**EL PASO COUNTY PLANNING AND  
 COMMUNITY DEVELOPMENT  
 DEPARTMENT**

**STORMWATER MANAGEMENT PLAN CHECKLIST**

Revised: July 2019

REGIONAL WATER QUALITY
CATCHMENT AREA A1
ROLLING HILLS RANCH PUD

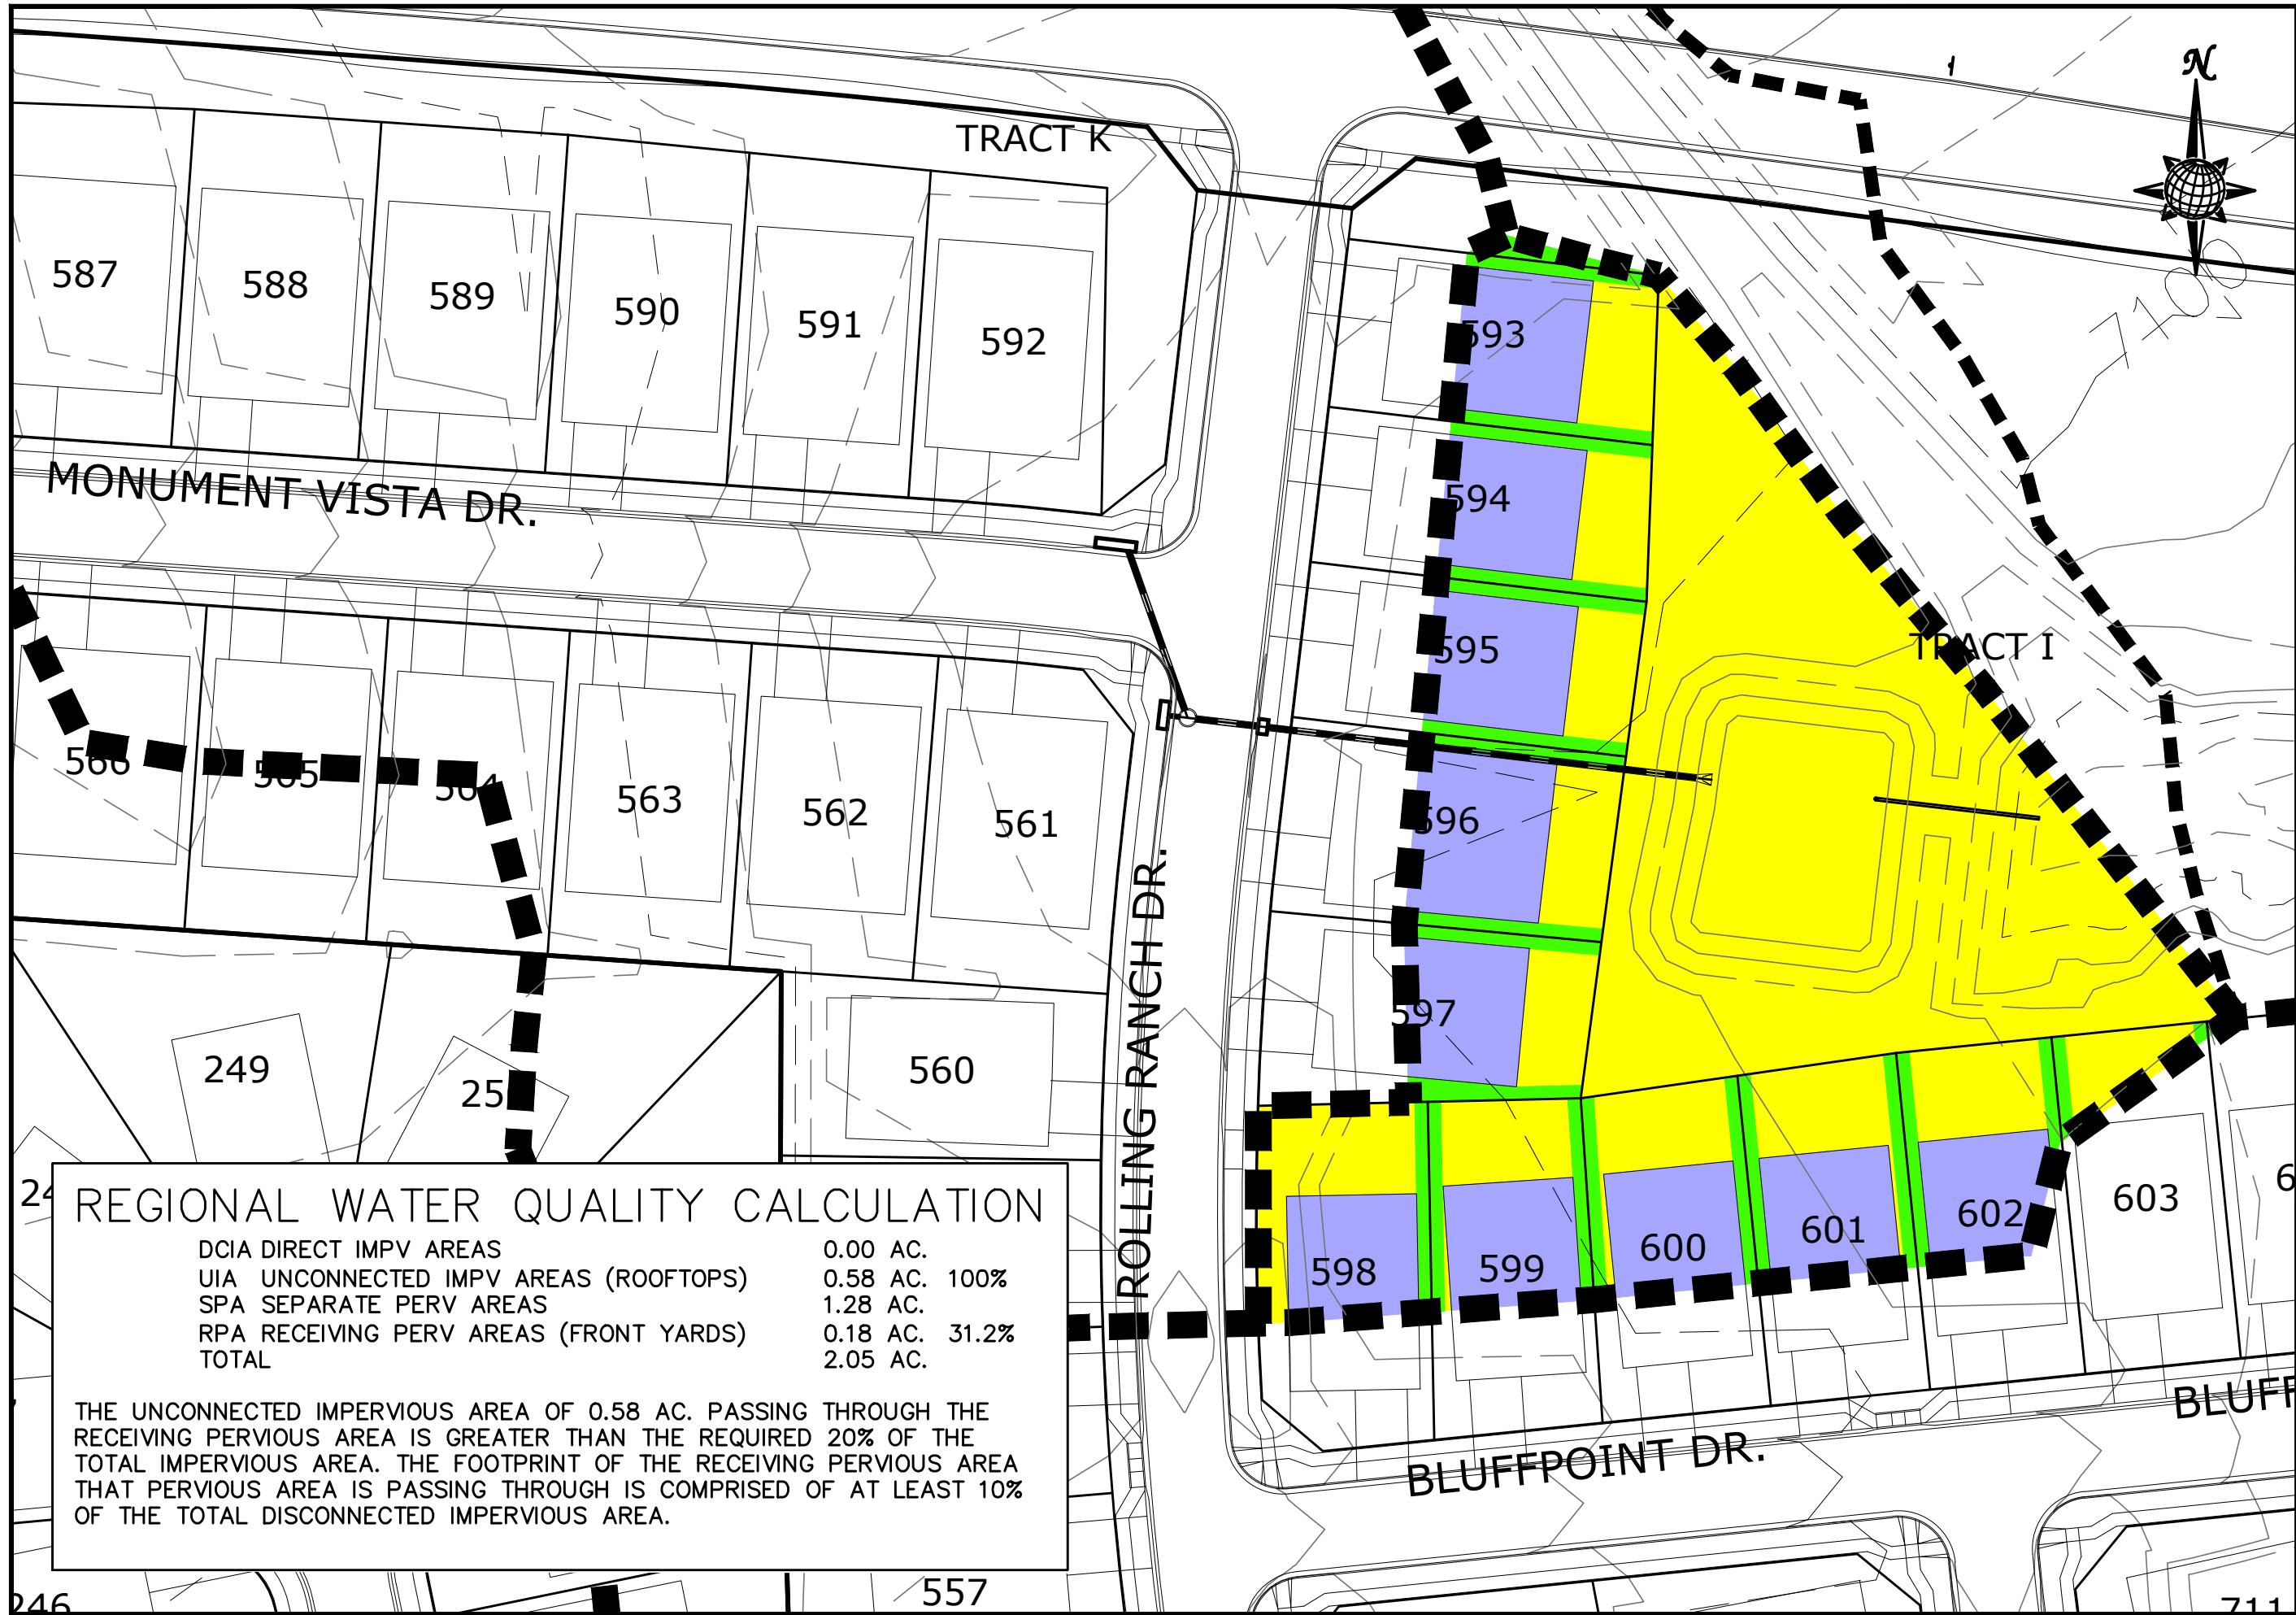
Please show or provide a statement that this will determined at a later date. Coordinate with Note 1. shown on the SWMP Site Map included in Appendices A and B.

Note added to Section 3.0 found on page 9 of the report
